Conservation Consultation Response:

From: Ian Heywood Planning Conservation Officer	To: DM Case Officer
Application no.	23/00771/FUL
Location	Barn At Dansons Farm Staynall Lane Hambleton Lancashire FY6 9DT
Description	Retrospective permission for change of use of agricultural building to single dwelling (C3), detached garage and change of use of land to domestic use
Date	23.08.2023

FRONT WEST ELEVATION PROPOSED

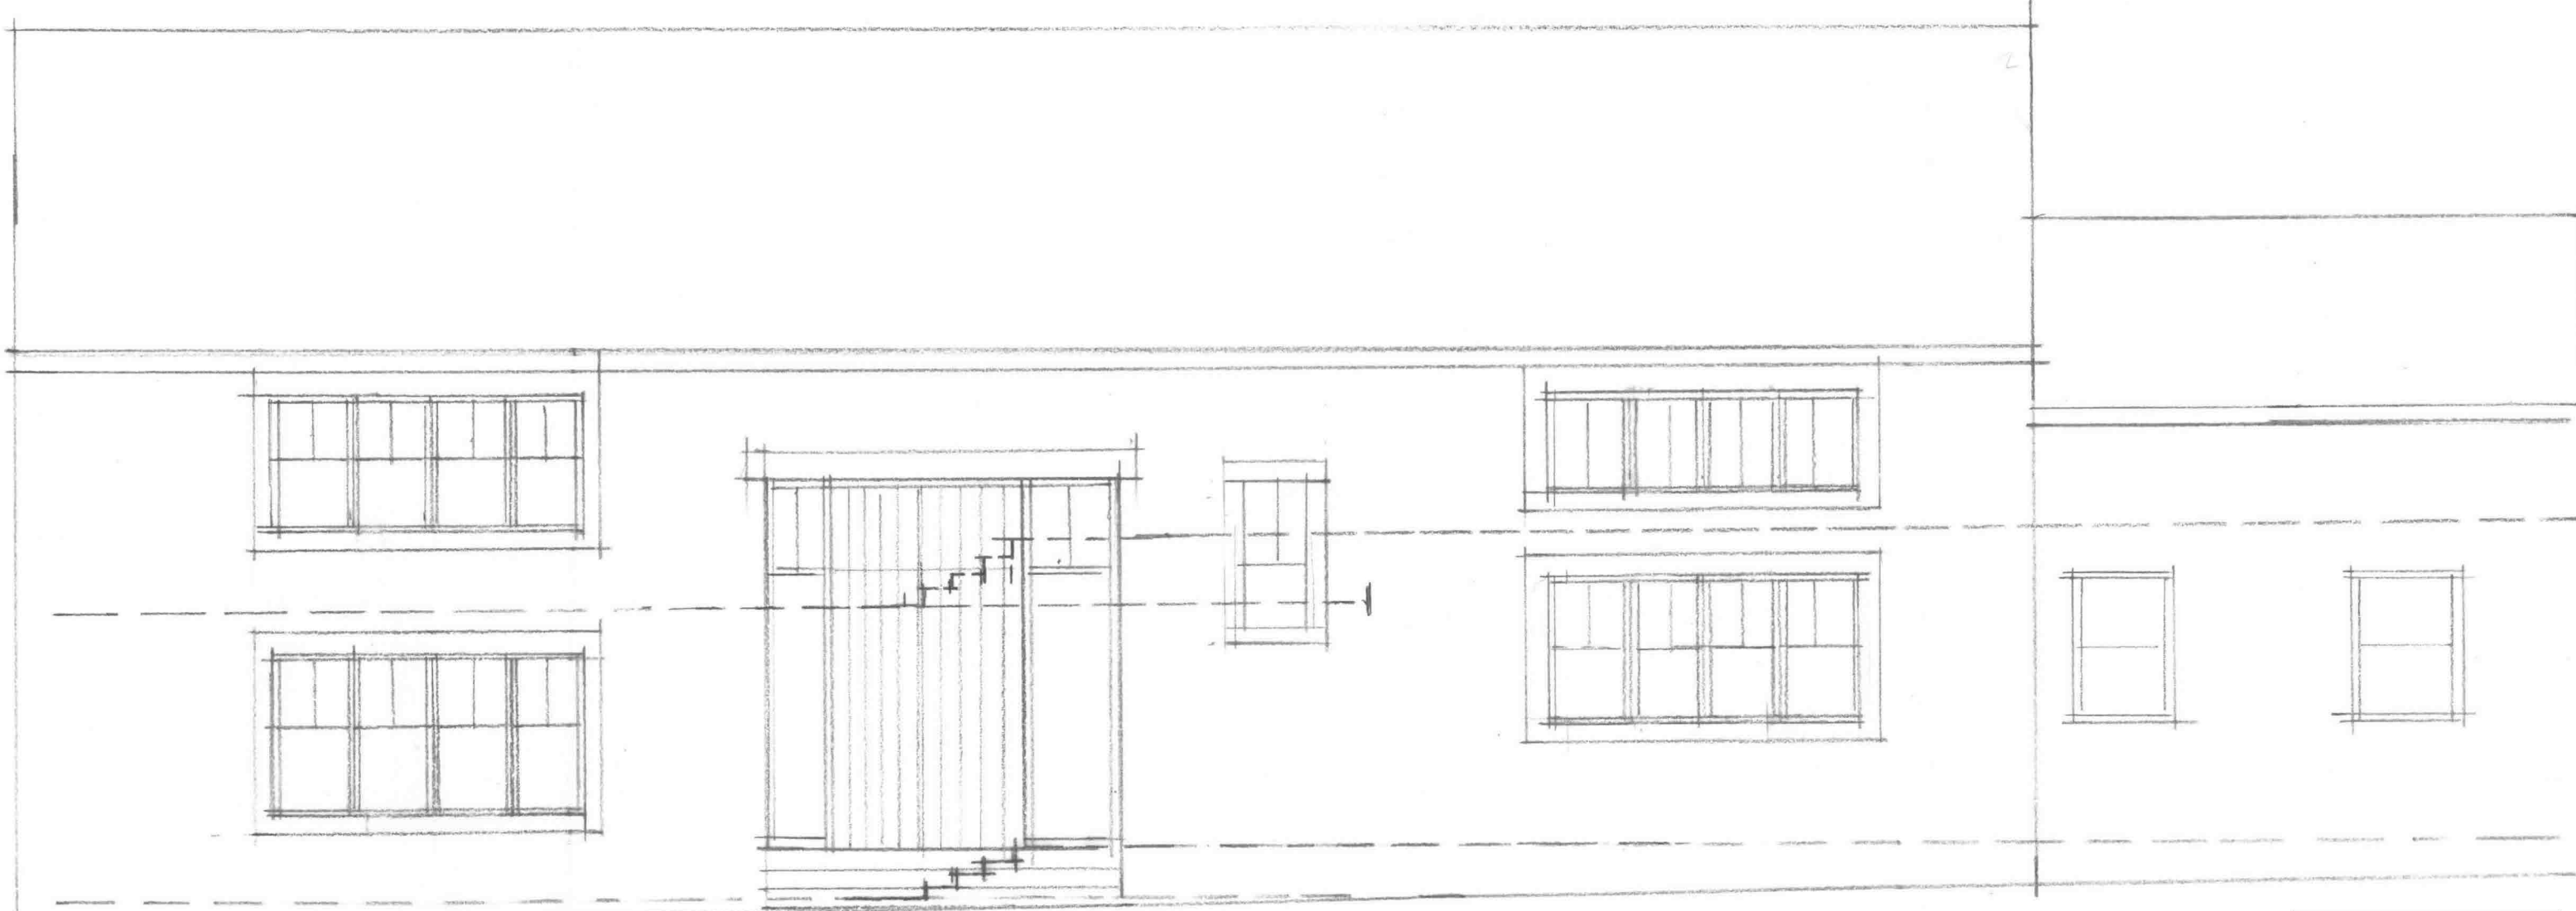
The works as carried out so far and as shown in the submitted proposed plans are unacceptable and cause substantial harm to the significance of this building but also to the setting of the listed building, Danson's Farmhouse. The number and size of new openings are completely unacceptable due to the large size and excessive number of them. The approved plans showed significantly smaller proposed new openings by comparison.

The window openings as executed so far and proposed are too large and domestic in style for a barn conversion. All semblance of retention of the original agricultural character of the building has and would be lost forever.
